Application no: **3/2021/0116**

Address: **Brackley Simonstone Lane Simonstone BB12 7NX**

Proposal: **Proposed new porch and vehicle hardstanding**

● Proposed Porch and Parking
BLOCK PLANS

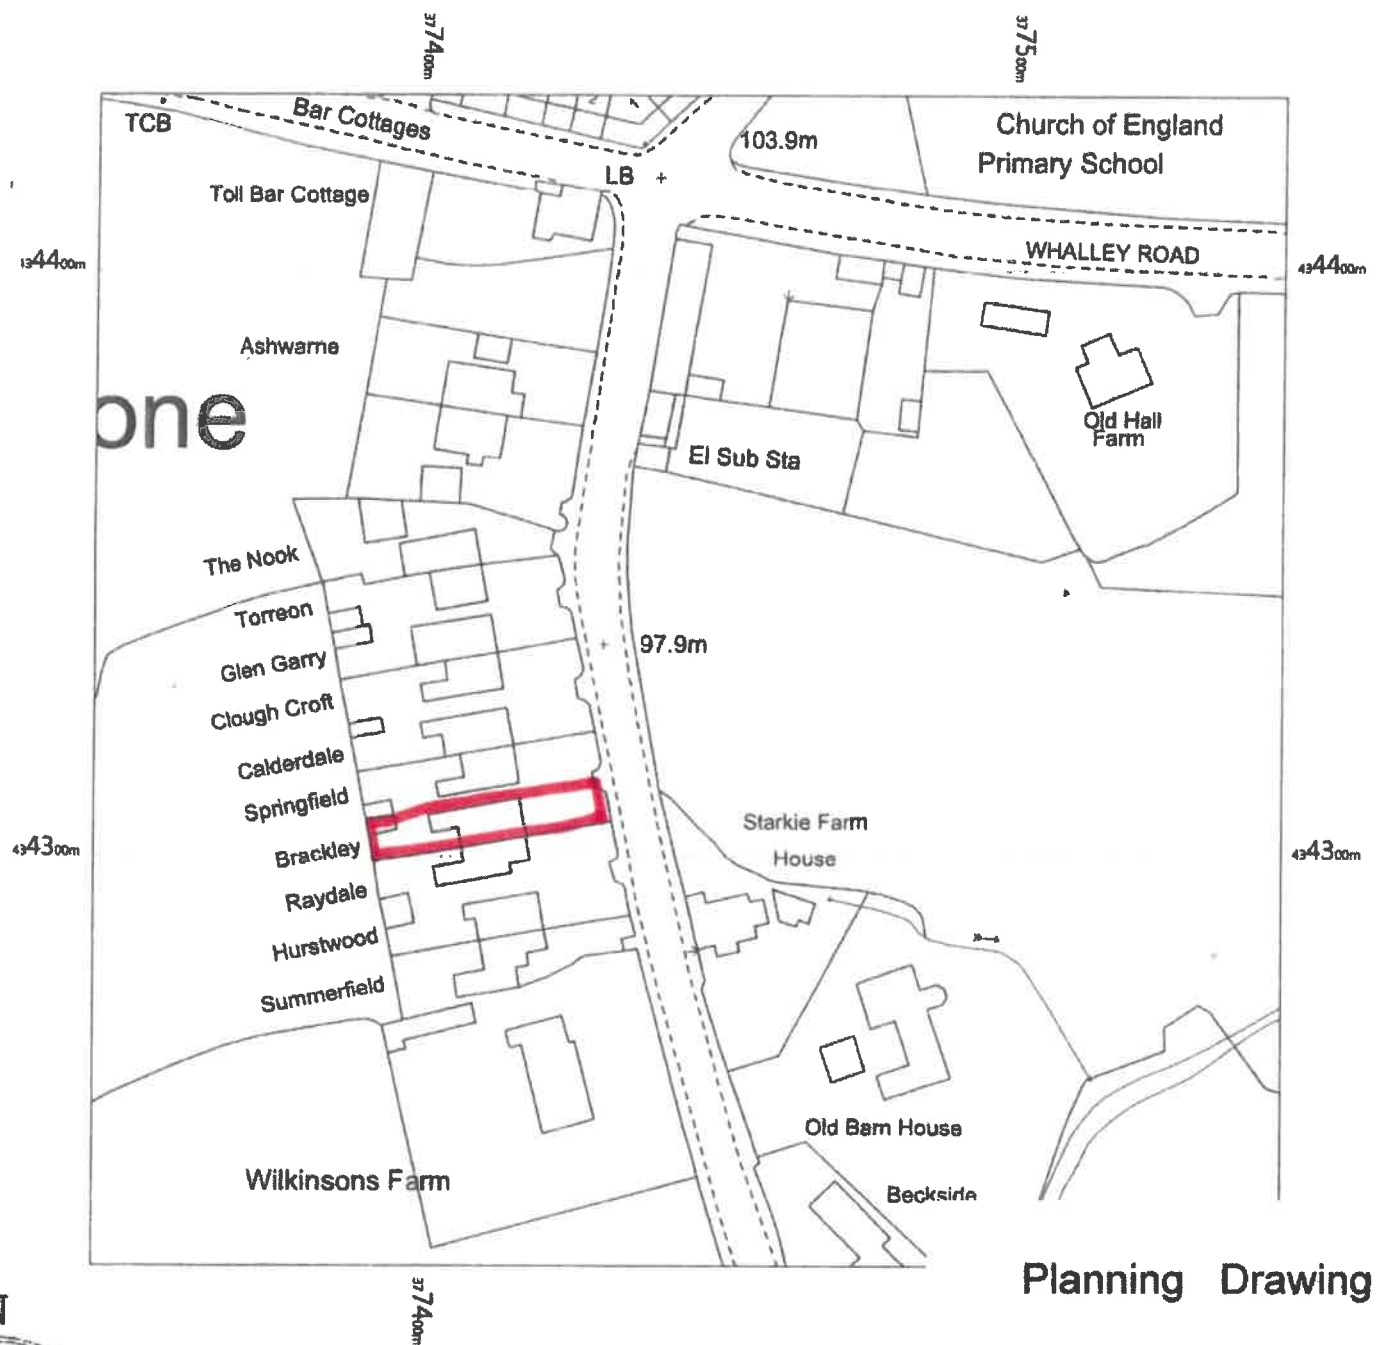
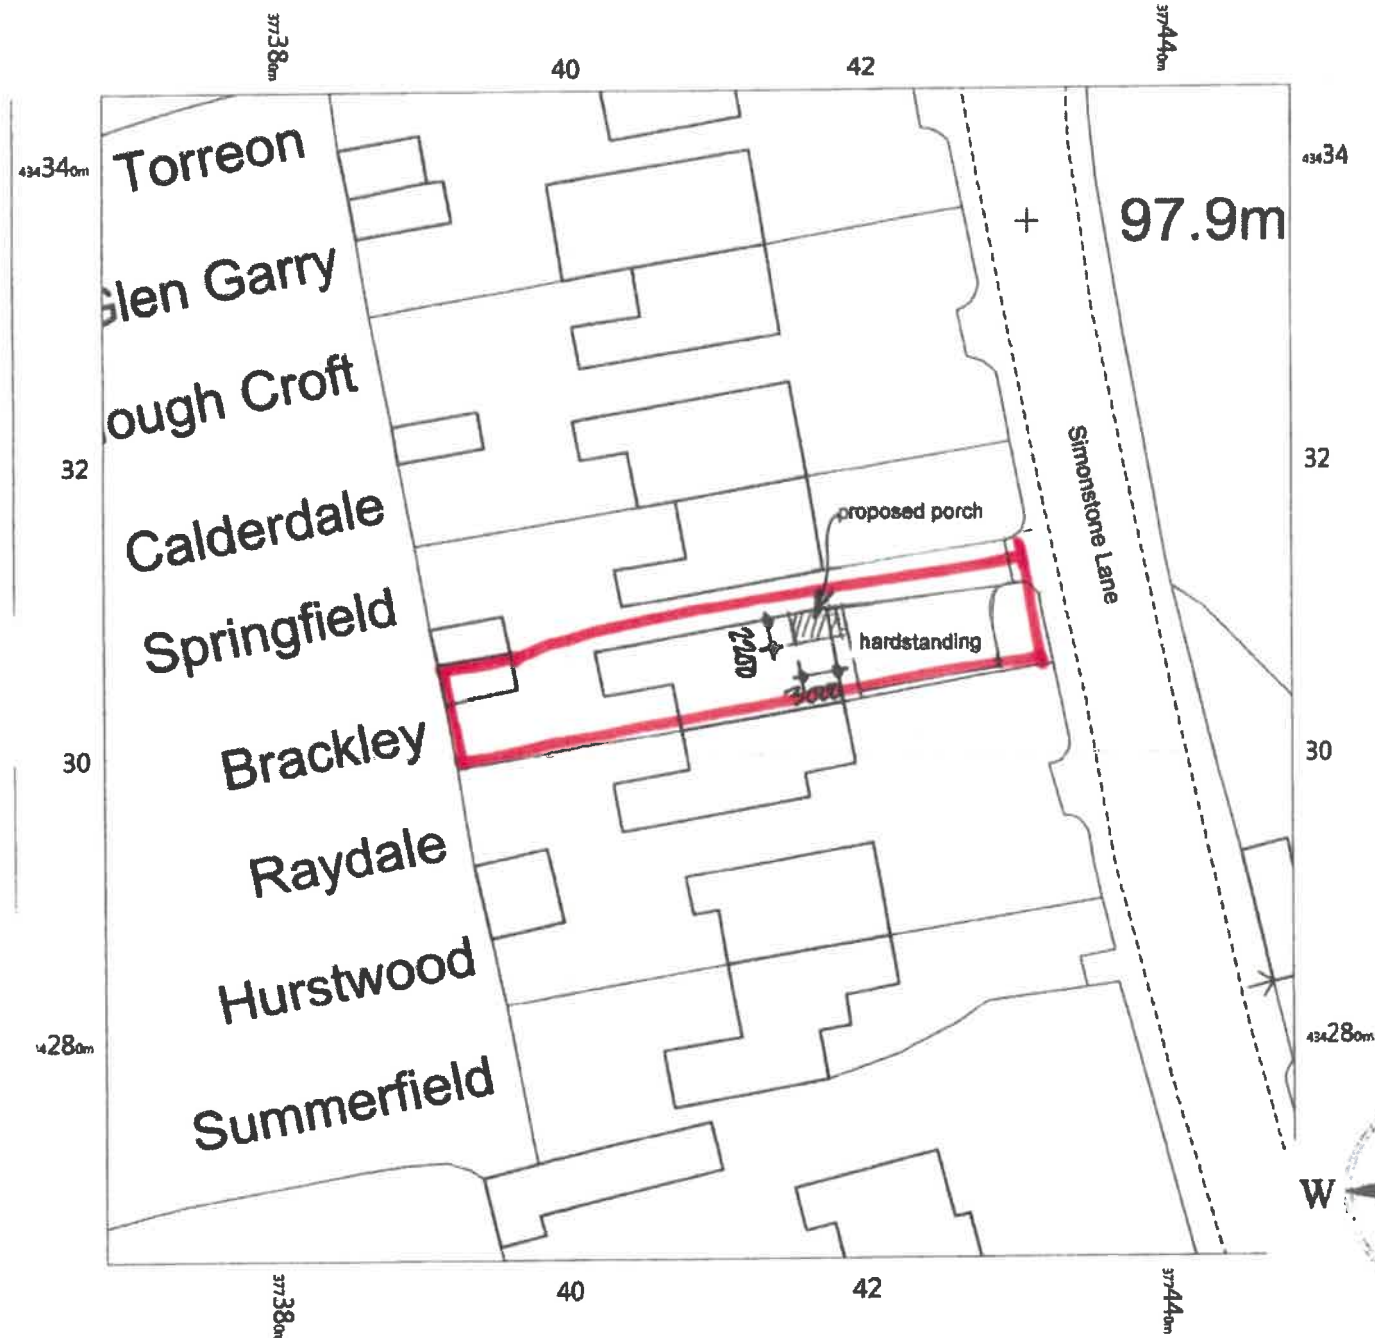
The proposed new porch and vehicle hardstanding will see alterations to the entrance of the property, resulting in an extension being required to the existing vehicular dropped crossing which will need to be carried out by Lancashire County Council under section 184 of the Highways Act 1980.

The applicant will be required to obtain the relevant permits to work on, or immediately adjacent to the adopted highway network prior to any of the access works being undertaken. The use of permeable surface course materials for the proposed hardstanding is something in which the local highway authority supports however without an exploratory ground investigation, the substratum may not be free draining and thus not support the concept of permeable hardstanding. Simonstone Lane has a history of issues regarding surface water run-off into the adopted highway and the local highway authority requests that the applicant provides measures to intercept any surface water run-off into the adopted highway from the application site.

1. The surface water from the approved driveway/hardstanding should be collected within the site and drained to a suitable internal outfall. Prior to commencement of the development details of the drainage strategy shall be submitted to and approved in writing by the Local Planning Authority. The scheme shall be implemented in accordance with the approved details.

2. Before the access is used for vehicular purposes, any gateposts erected at the access shall be positioned 5m behind the nearside edge of the highway and visibility splay fences or walls shall be erected from the gateposts to the existing highway boundary, such splays shall be 45° to the centre line of the access. The gates shall open away from the highway. Should the access remain un-gated 45° splays shall be provided between the highway boundary and points on either side of the drive measured 5m back from the nearside edge of the highway.
